Date: 19-Jun-2026
Our Ref: 2025/90352

**Application for Approval of Details Reserved by Condition
Town and Country Planning Act 1990
Planning (Listed Buildings and Conservation Areas) Act 1990**

Discharge of details reserved by conditions 6 (boundary treatments), 8 (intrusive site investigations and remedial works), 9 (declaration), 10 (Phase I Desk study Report), 11 (Phase II Intrusive Site Investigation Report), 12 (Remediation Strategy), 13 (Remediation Strategy), 14 (Verification Report) and 15 (Arboricultural Method Statement and Tree Protection Plan) of previous permission 2024/93464 for variation condition 2 (plans) on previous permission 2023/91483 for demolition of garage and erection of detached dwelling.

**adj, 33a, Church Lane, Clayton West, Huddersfield, HD8 9LY
Application Number: 2025/90352**

Remediation Plan

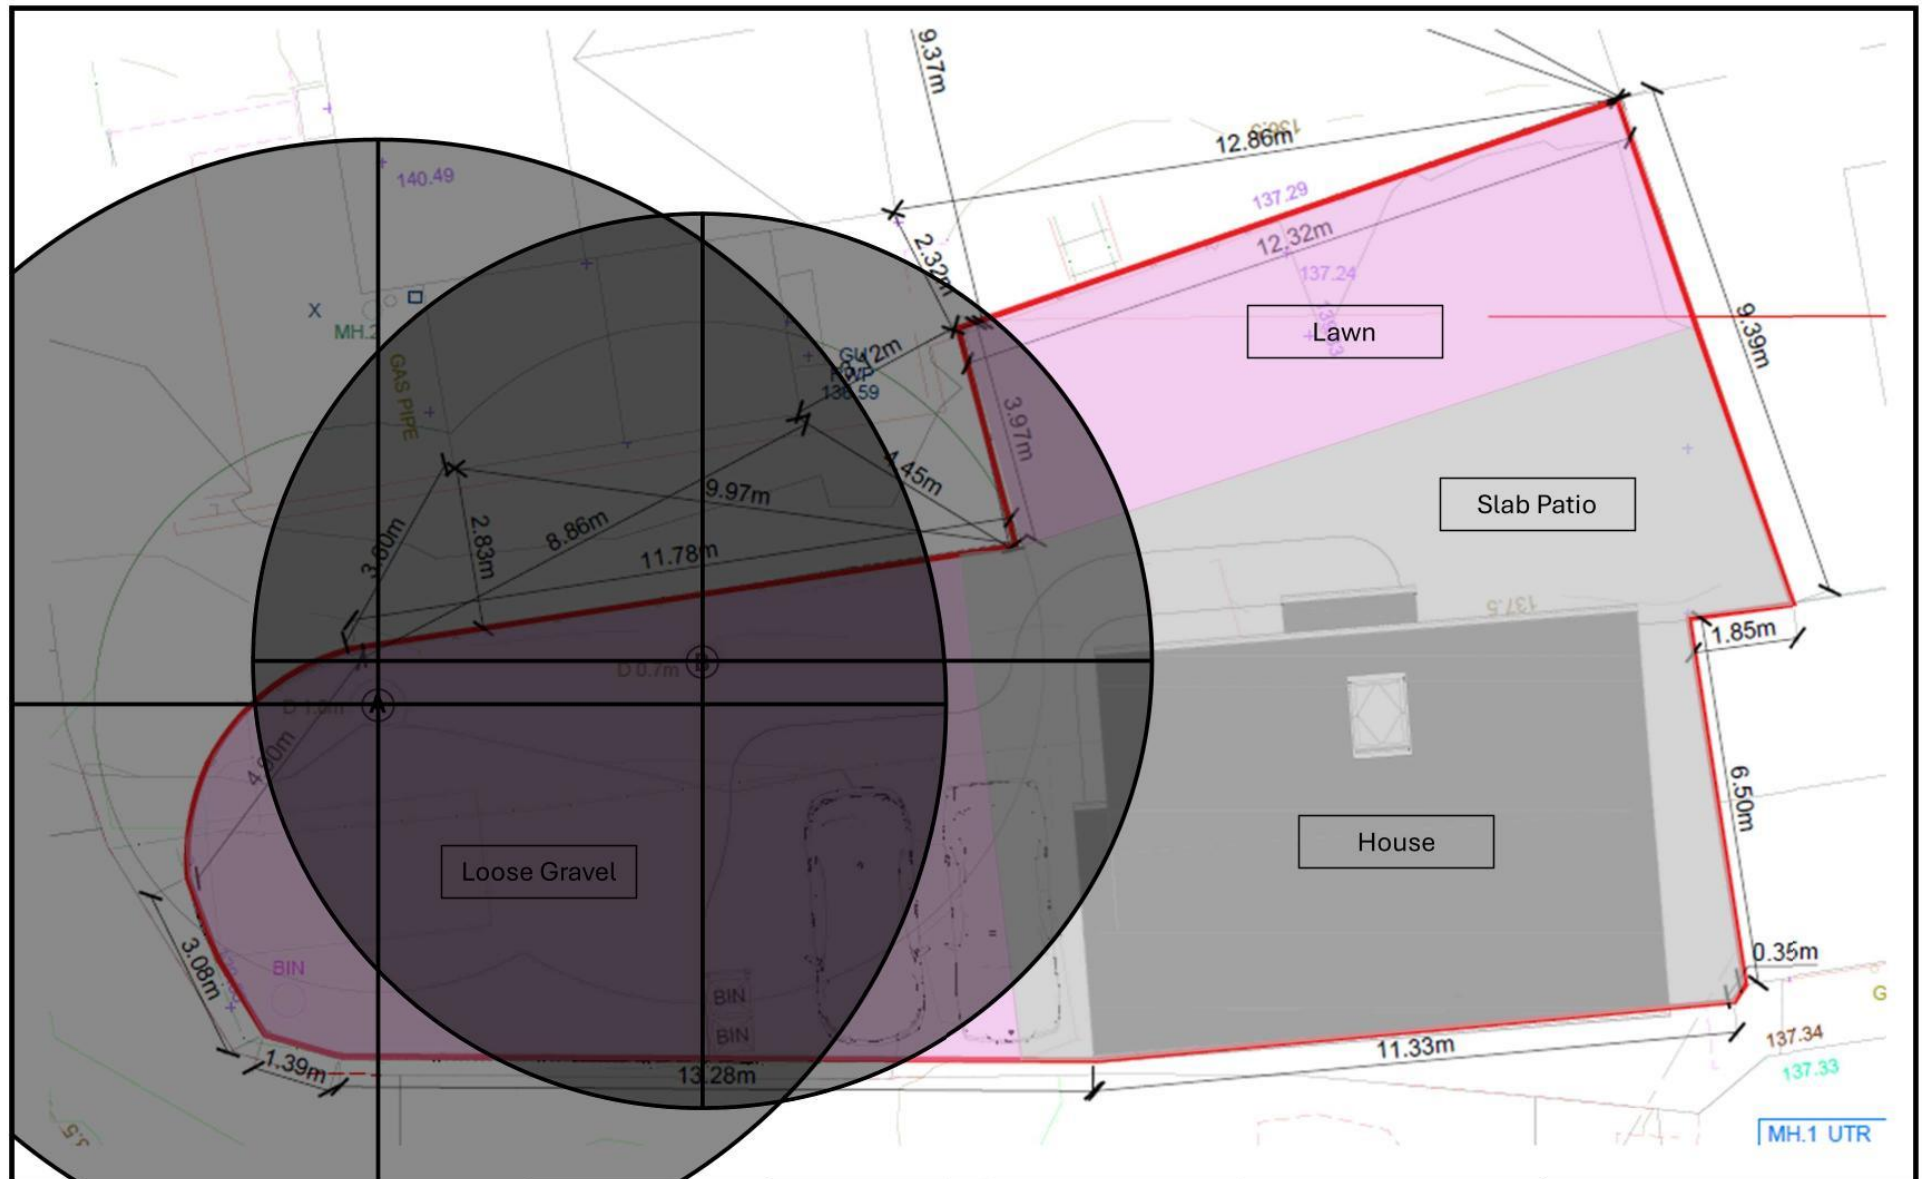
We note in the Remediation Plan, appendix 1, the 300mm of clean cover proposed is extended to the entire soft landscaped areas and not just areas identified as tree root protection zones.

We do not accept the Remediation Strategy Report by Geoinvestgate, dated April 2025, ref: G24327, the 300mm clean cover depth in soft landscaped areas may be insufficient to ensure there is adequate protection for end-users. We therefore request that the contaminated land consultant provide further information to address these concerns.

Additional risk assessment, GI or revised proposals may be necessary. This must be undertaken by a competent person as defined in the NPPF. Any new information must confirm, to a high degree of confidence, that the remediation strategy will ensure adequate protection for end users.

Appendix 2 Tree Protection Plan

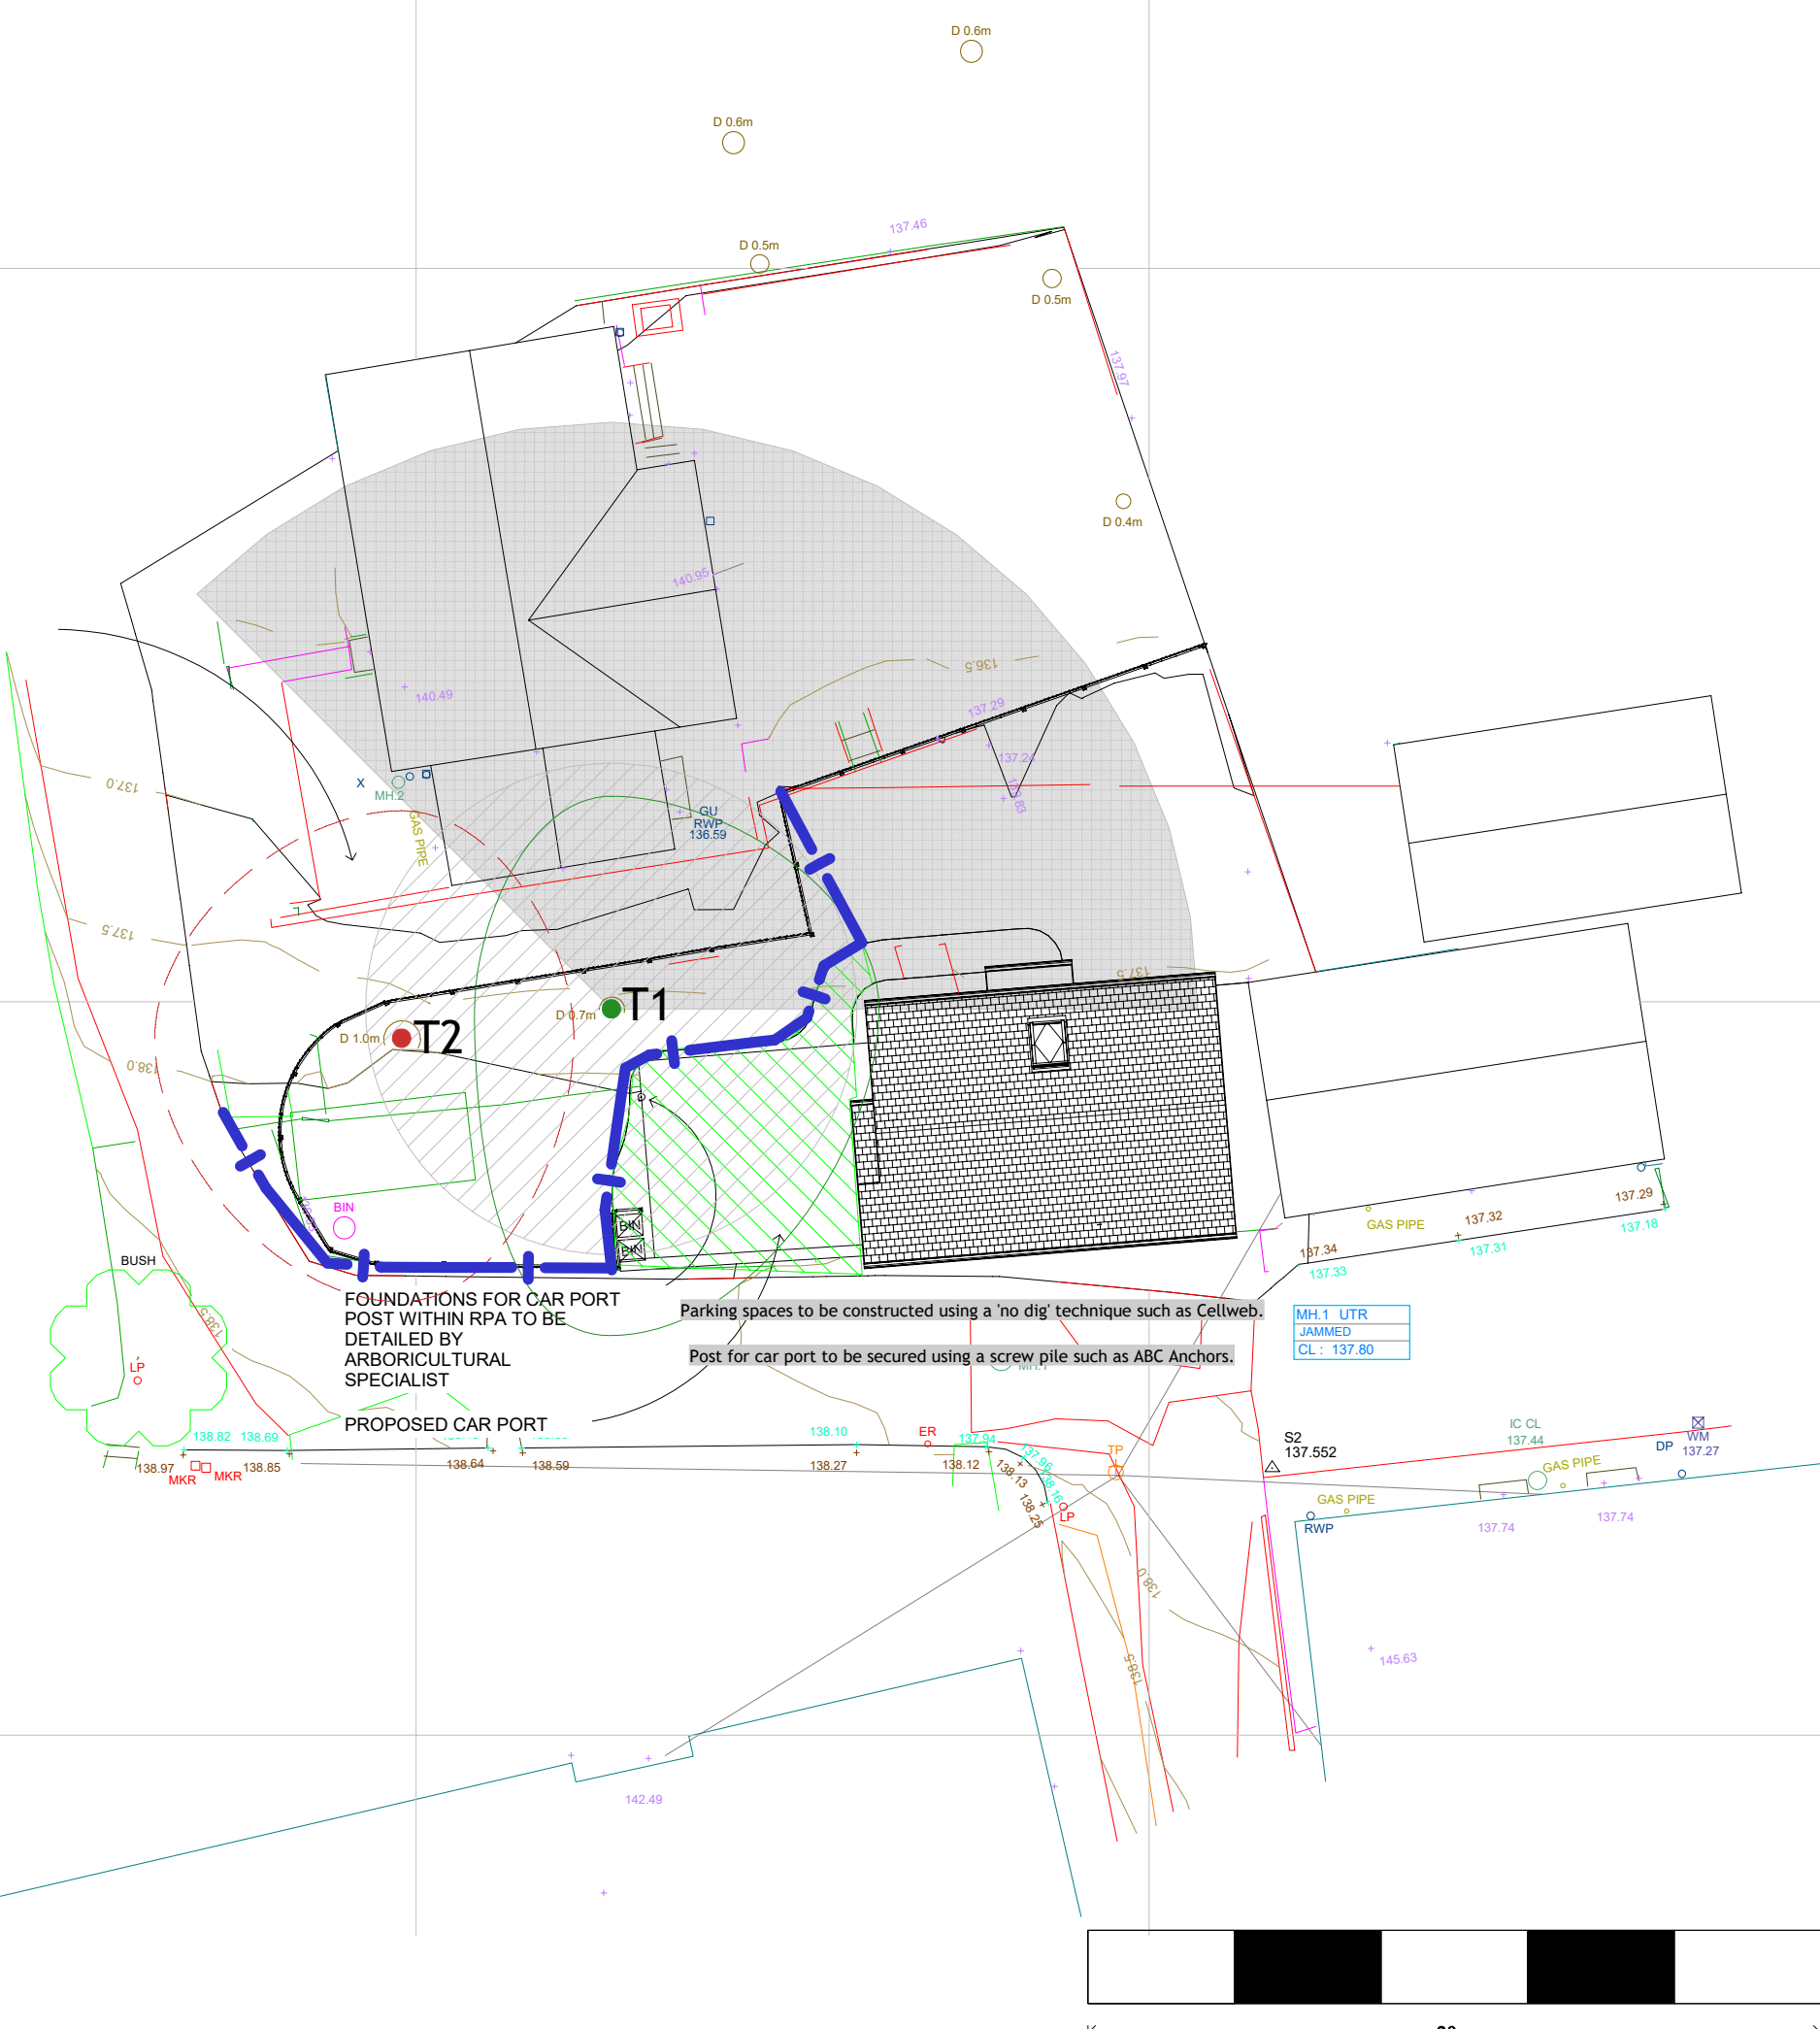
However, officers have reviewed the planning history on site and understand that T2 was agreed to be removed as part of the previous decision notice and therefore the submitted document Roavr Group 25_5837_07_112 contains inaccuracies as T2 has been removed on site.
